An  
Coimisiún  
Pleanála

**Direction**  
**ABP-320327-24**

The submissions on this file and the Inspector's report were considered at a meeting held on 19/11/2025.

at Kippure Lodge and Holiday Village, Kippure Estate, Manor Kilbride, Blessington, County Wicklow is or is not development or is or is not exempted development:

Structure 03

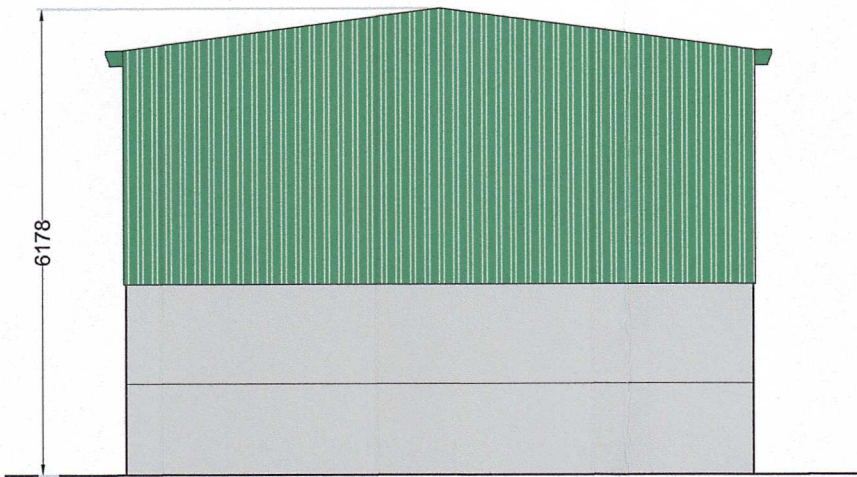
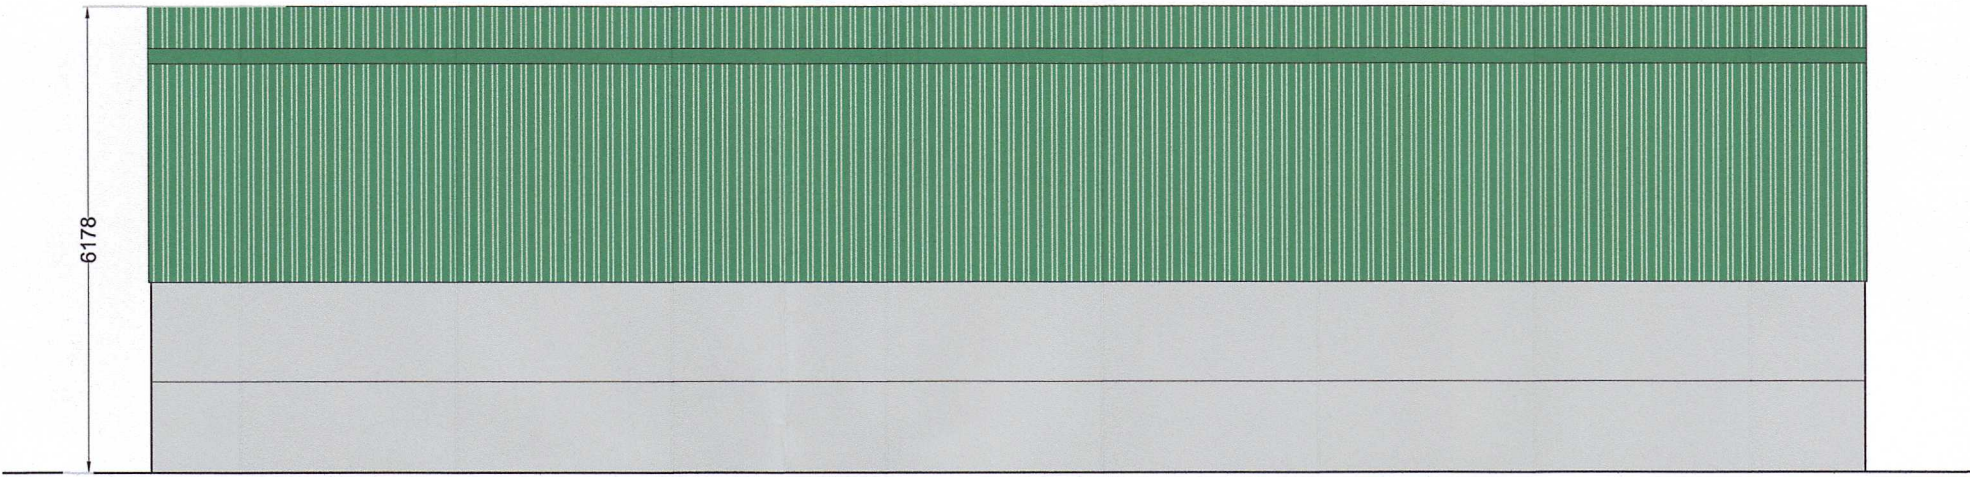
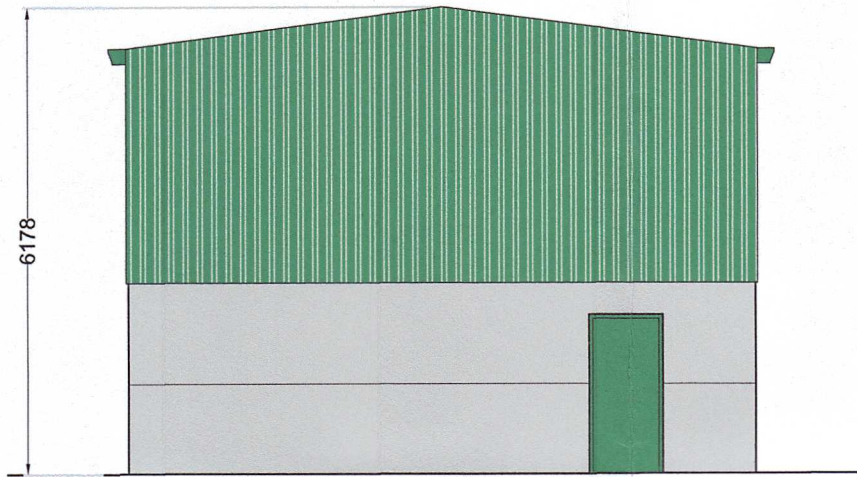
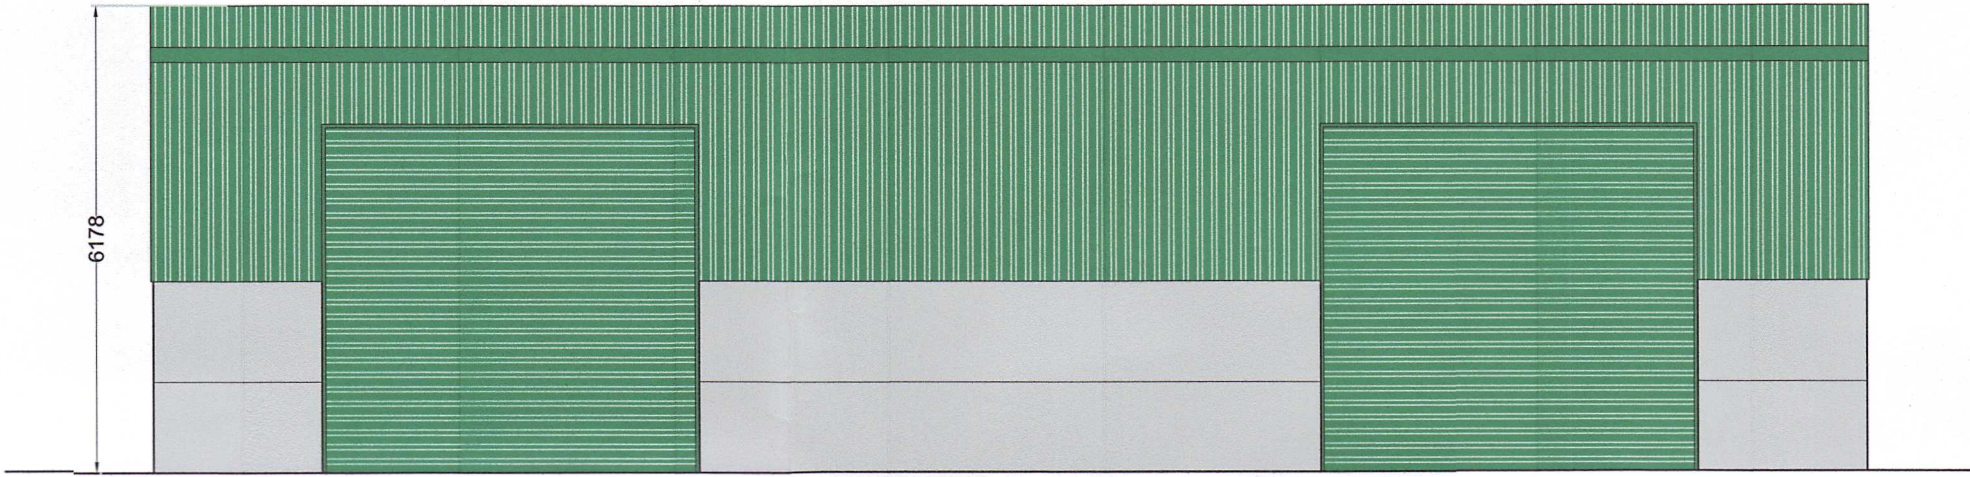
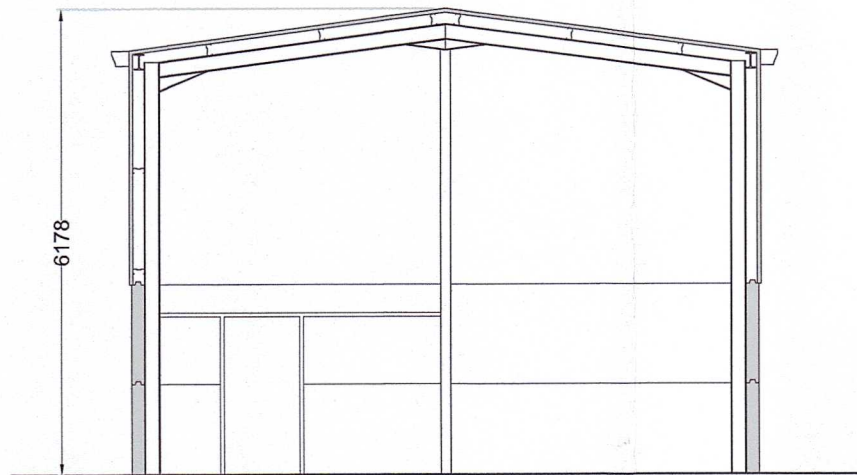
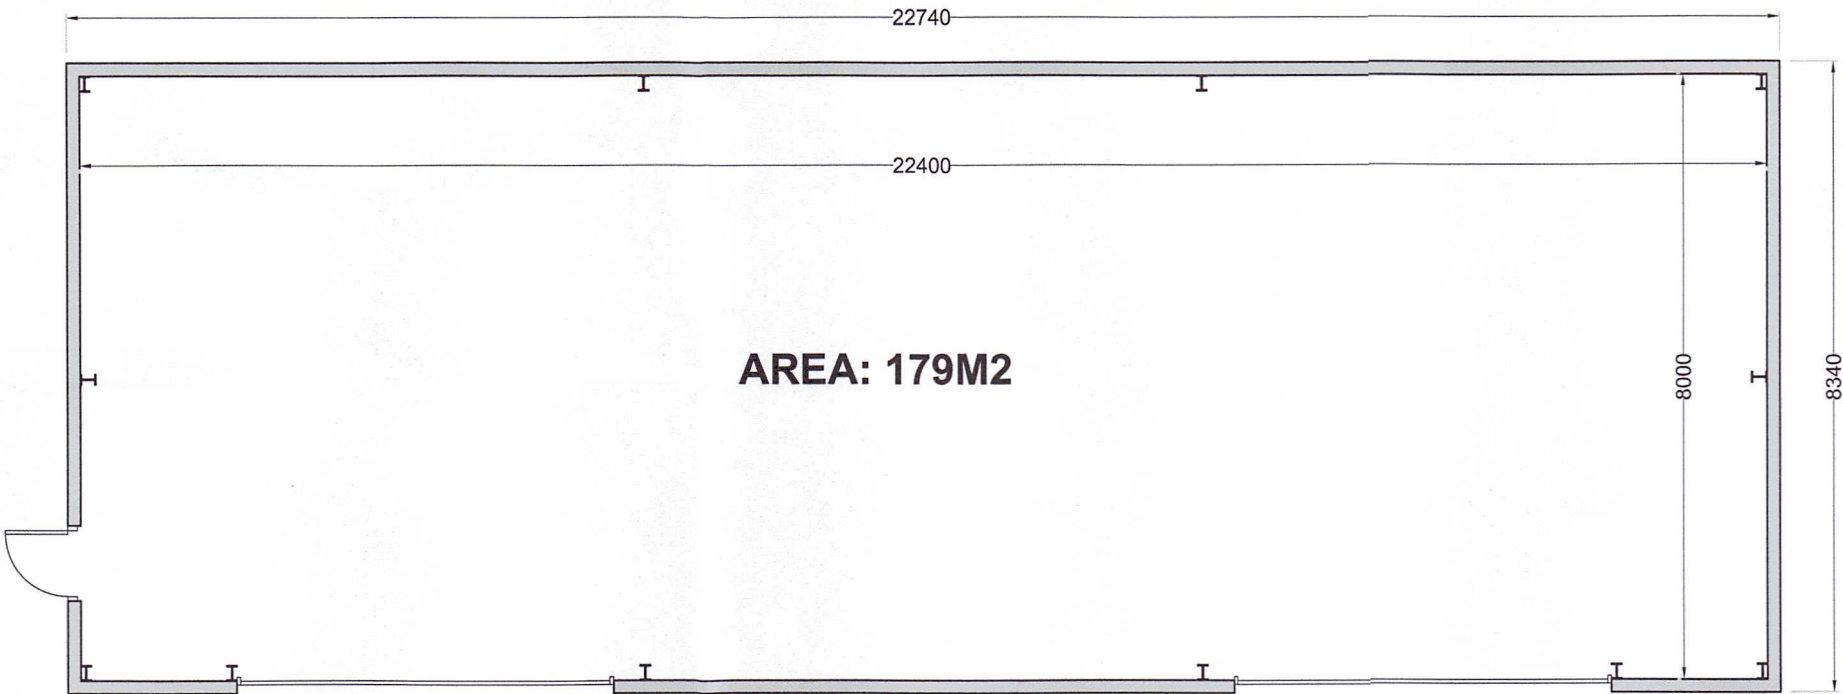
- (c) Structure Number 3: Detached agricultural maintenance storage facility does not fall within the scope of Class 9 of Part 3 of Schedule 2 of the Planning and Development Regulations, 2001 (as amended) as the use of the structure for agriculture or forestry has not been adequately demonstrated. In addition, the aggregate gross floor space of the structure, with other such structures within 100 metres, exceeds the 900 square metres limitation. Therefore, this structure does not constitute exempted development.

Structure 05

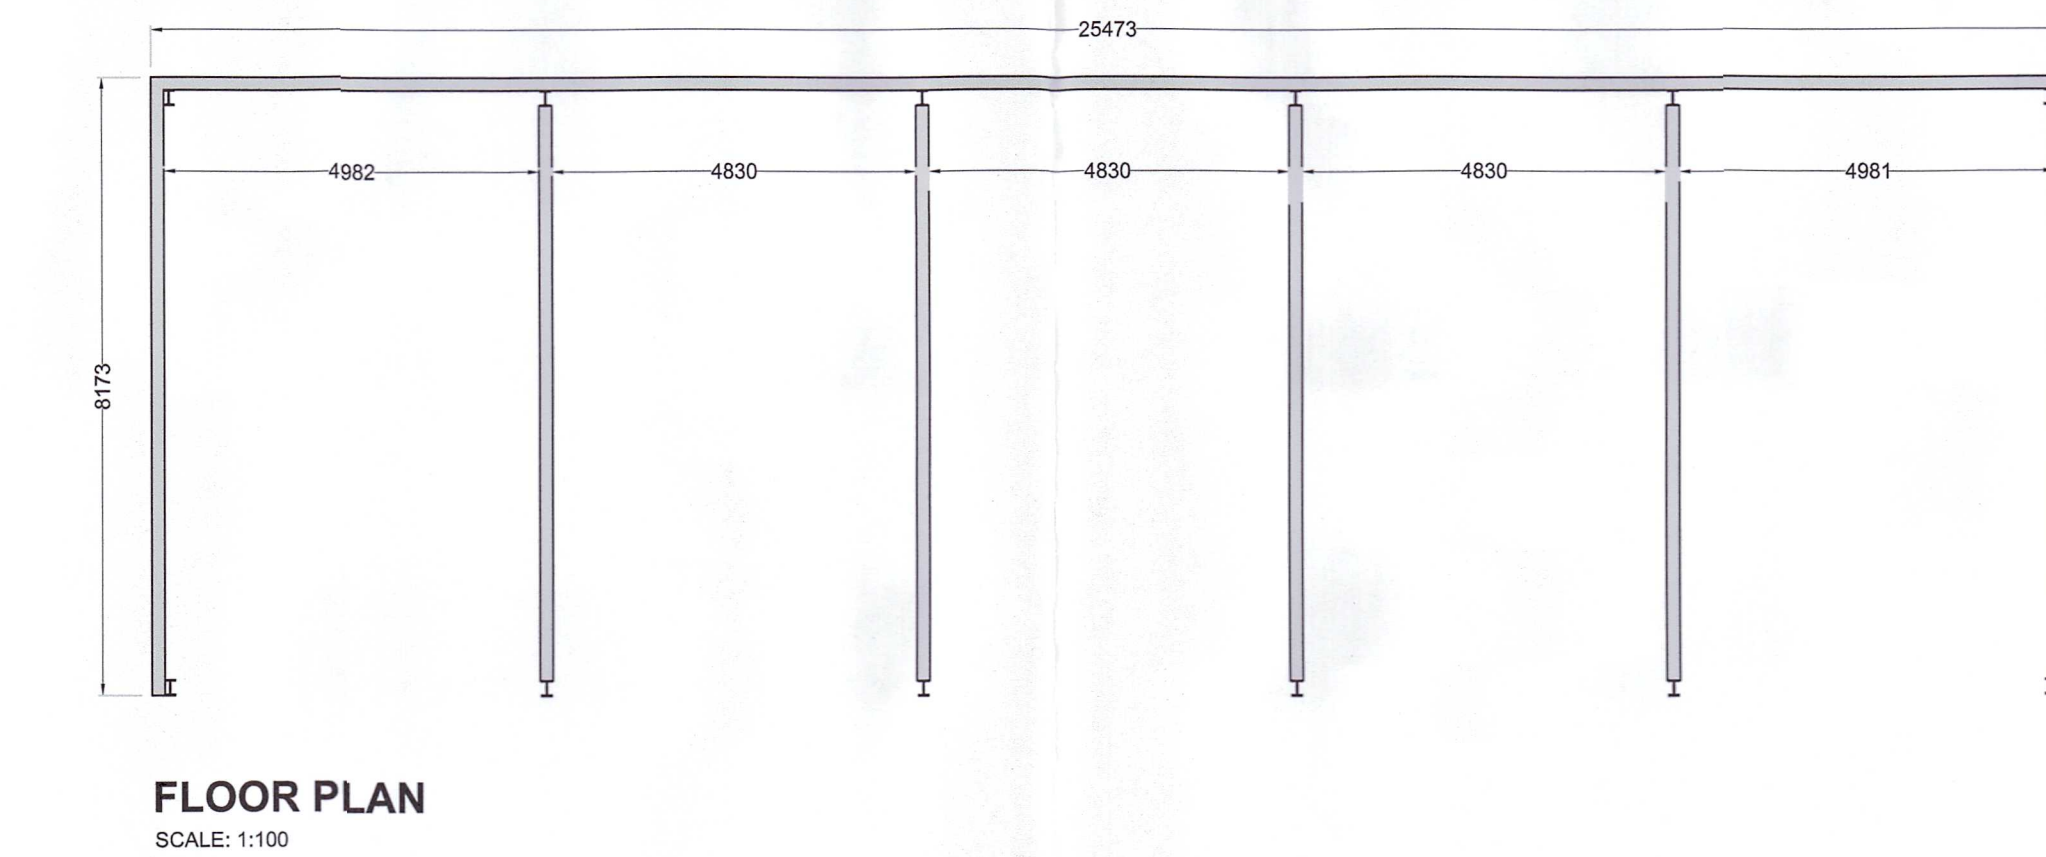
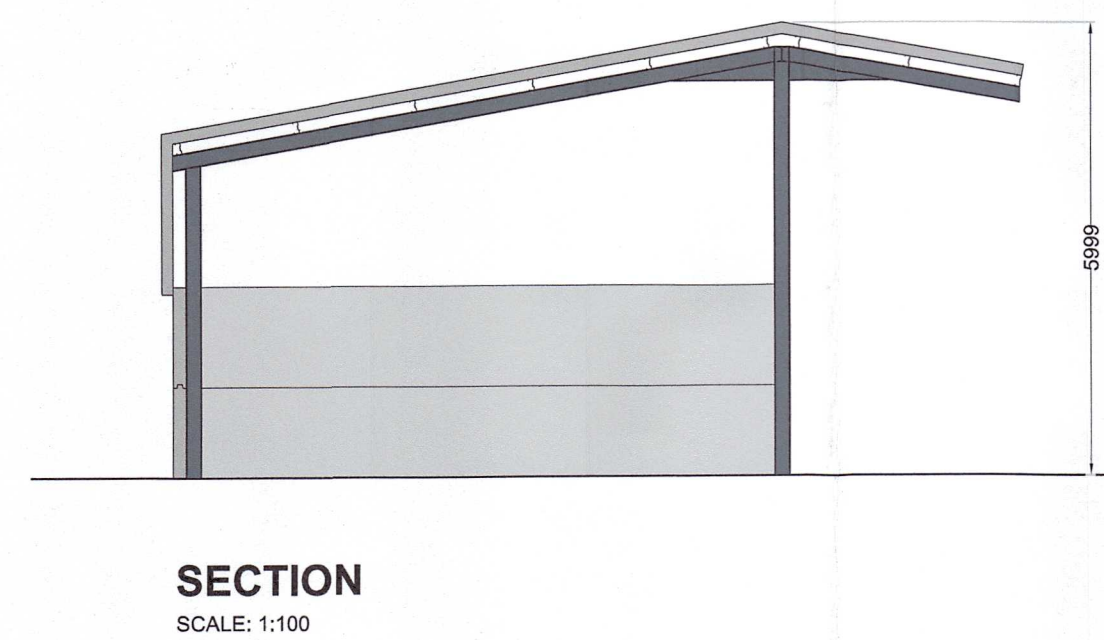
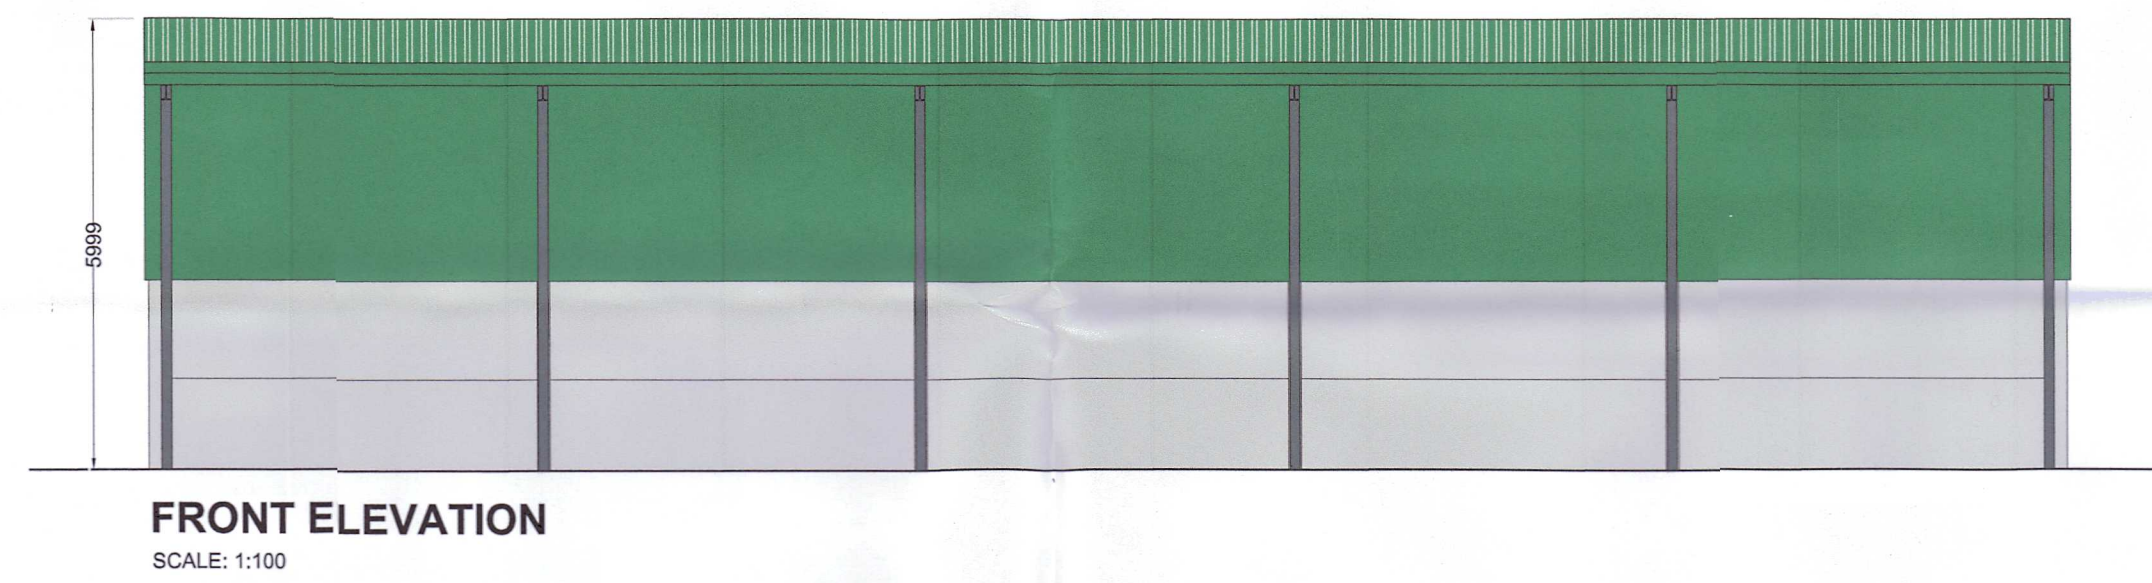
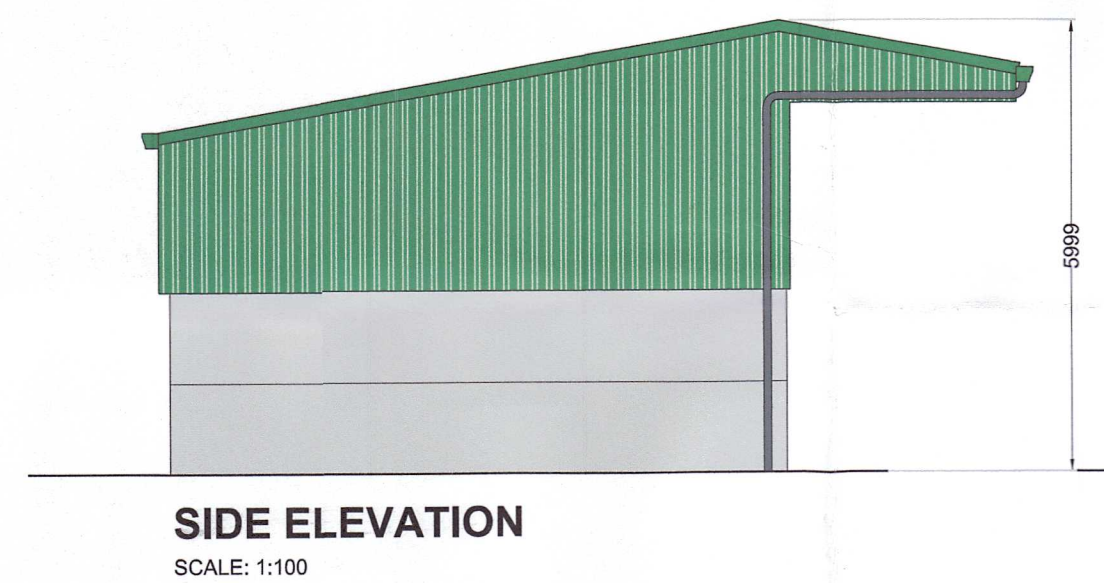
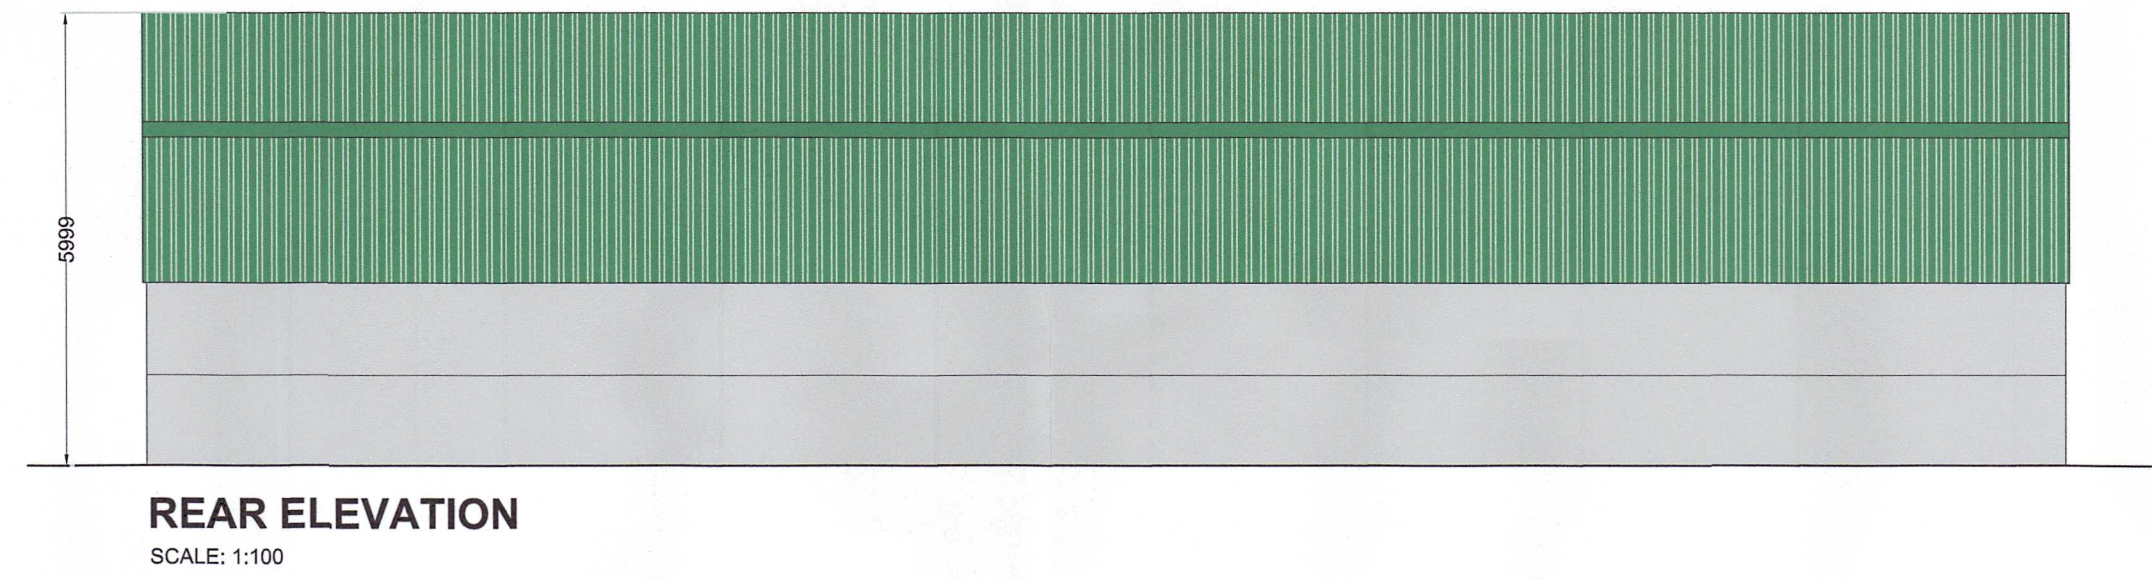
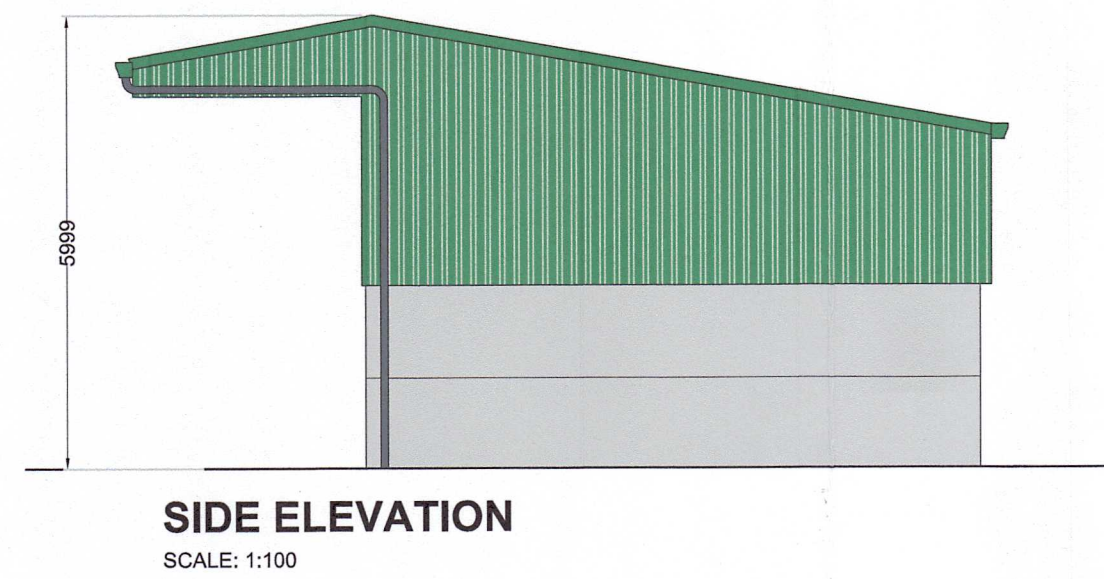
- (e) Structure Number 5: Open fronted agricultural shed does not fall within the scope of Class 9 of Part 3 of Schedule 2 of the Planning and Development Regulations, 2001 (as amended) as the use of the structure for agriculture or forestry has not been adequately demonstrated. In addition, the aggregate gross floor space of the structure, with other such structures within 100 metres, exceeds the 900 square metres limitation. Therefore, this structure does not constitute exempted development.
